# Condition Compliance Document

## Suncadia Ph 3 Div 18 Short Plat File Number SP-25-00007 Compliance Document

DWN. BY CAF	DATE 2025-07-30	JOB NO. 998-847-022-0203
CHKD. BY CAF	SCALE 1"=80'	SHEET 2 OF 3

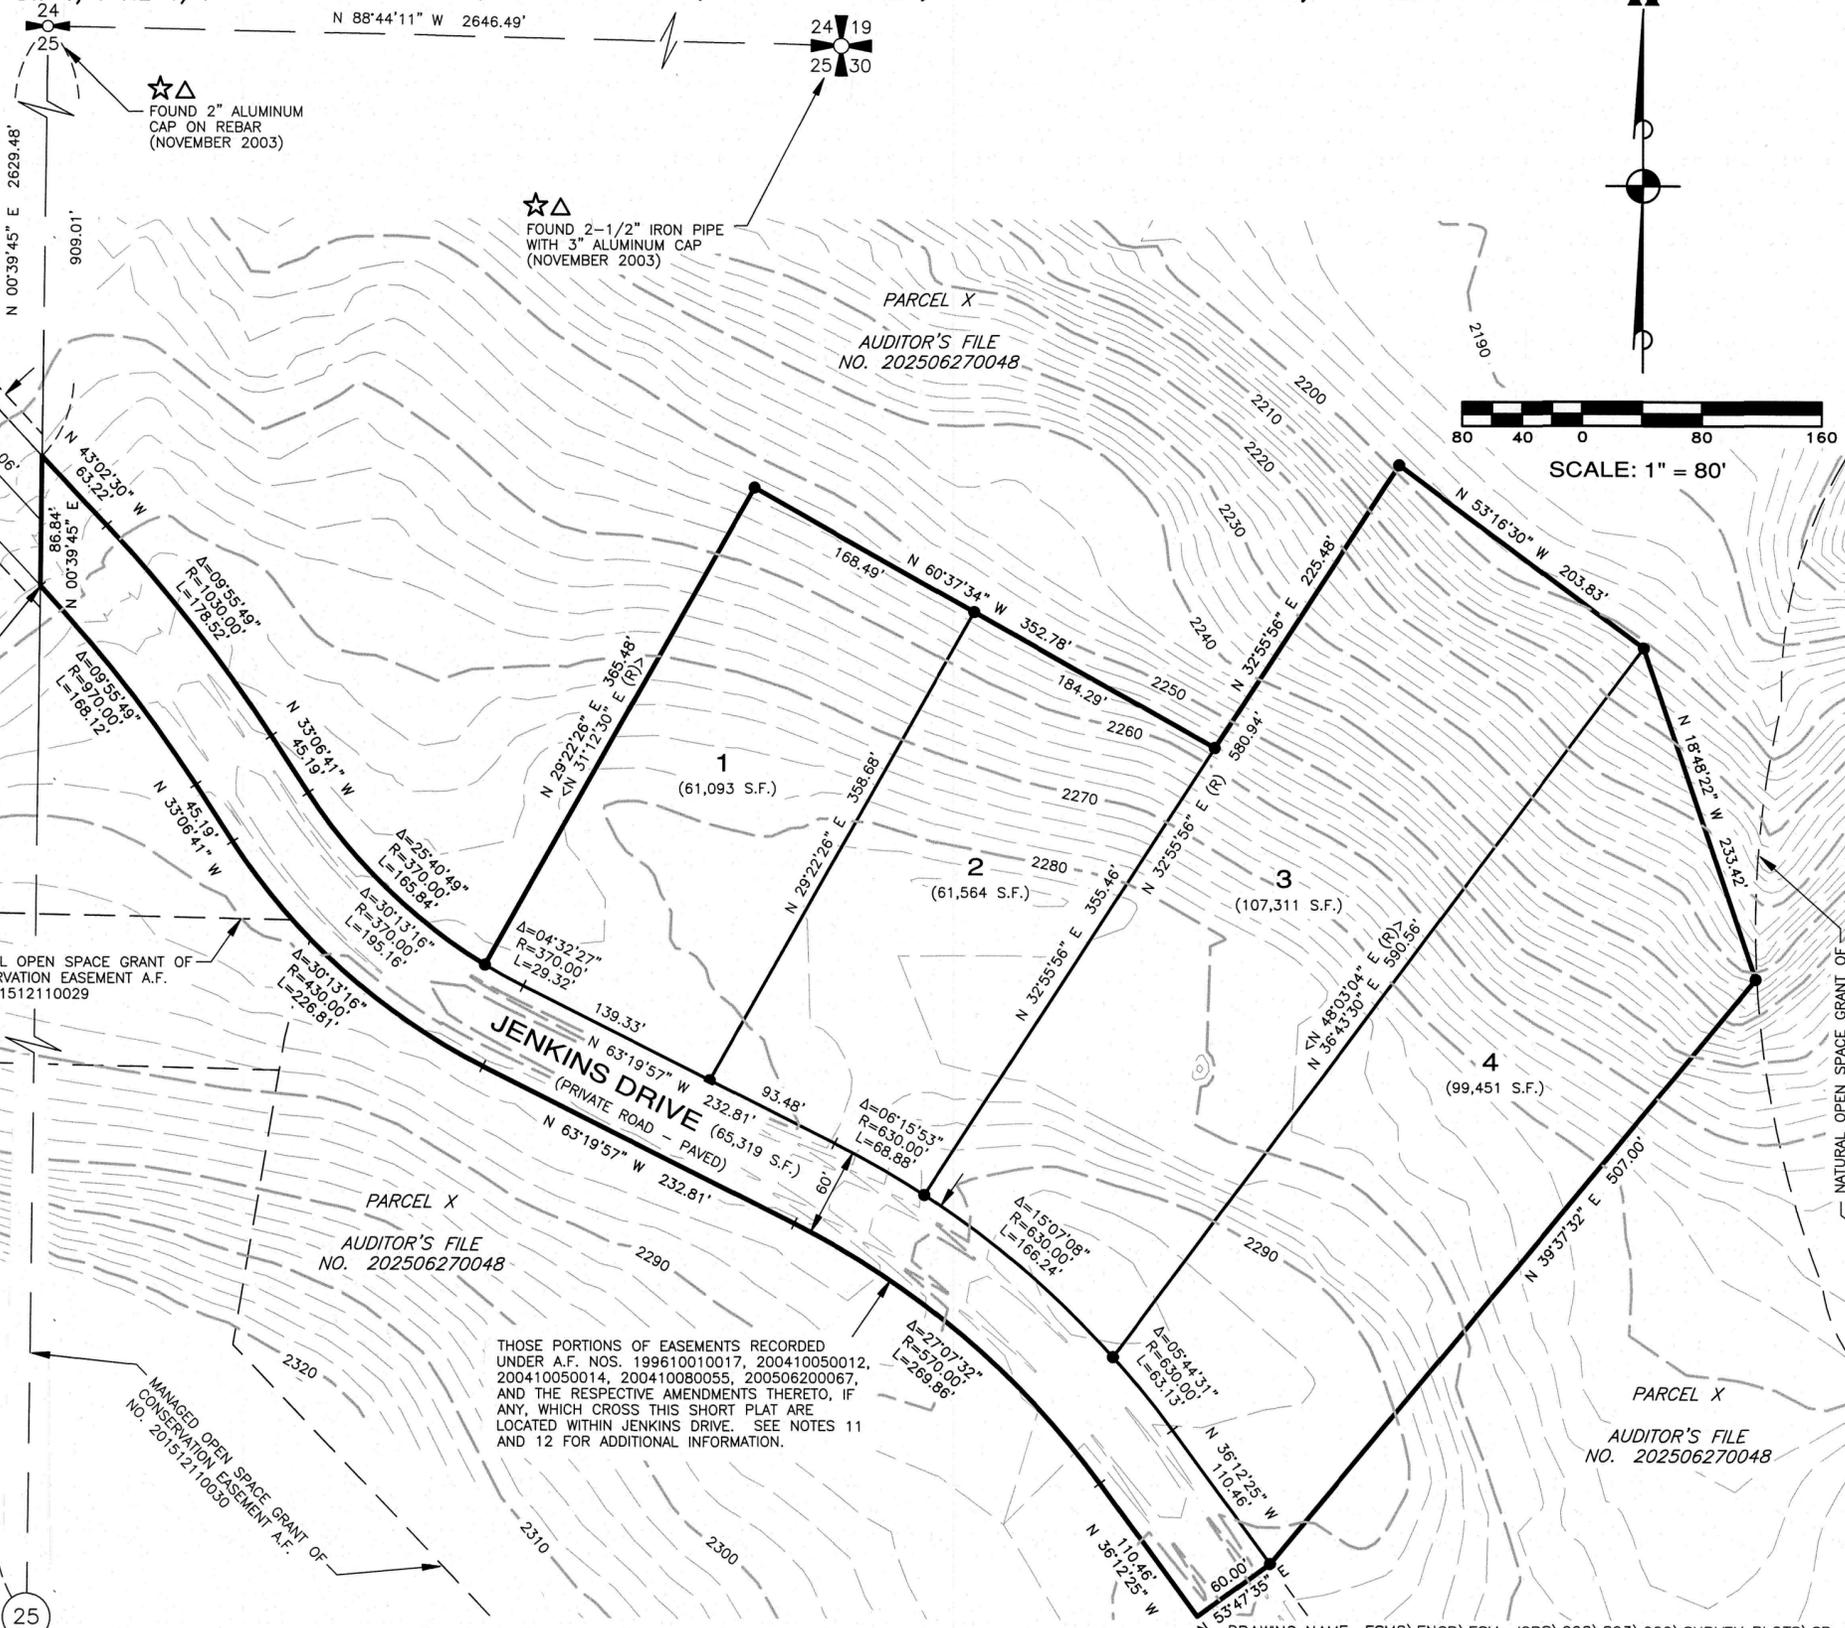
Survey Comment 4. Existing Contours are to be shown, and sufficient data included to meet the requirements of WAC:332-130-145.	Existing contours have been added in accordance with WAC 332-130-145.	
Survey Comment 5. Please Show "Short Plat" at the top of the page, together with a unique name for the subdivision.	The title "Short Plat" and the unique name "Tumble Creek Division 18 Block 1" was added to the top of the plat sheets.	
Transportation Concurrency	No Comment.	
Flood	No response necessary.	
Water Mitigation / Metering	No Comment.	
Airport	No Comment.
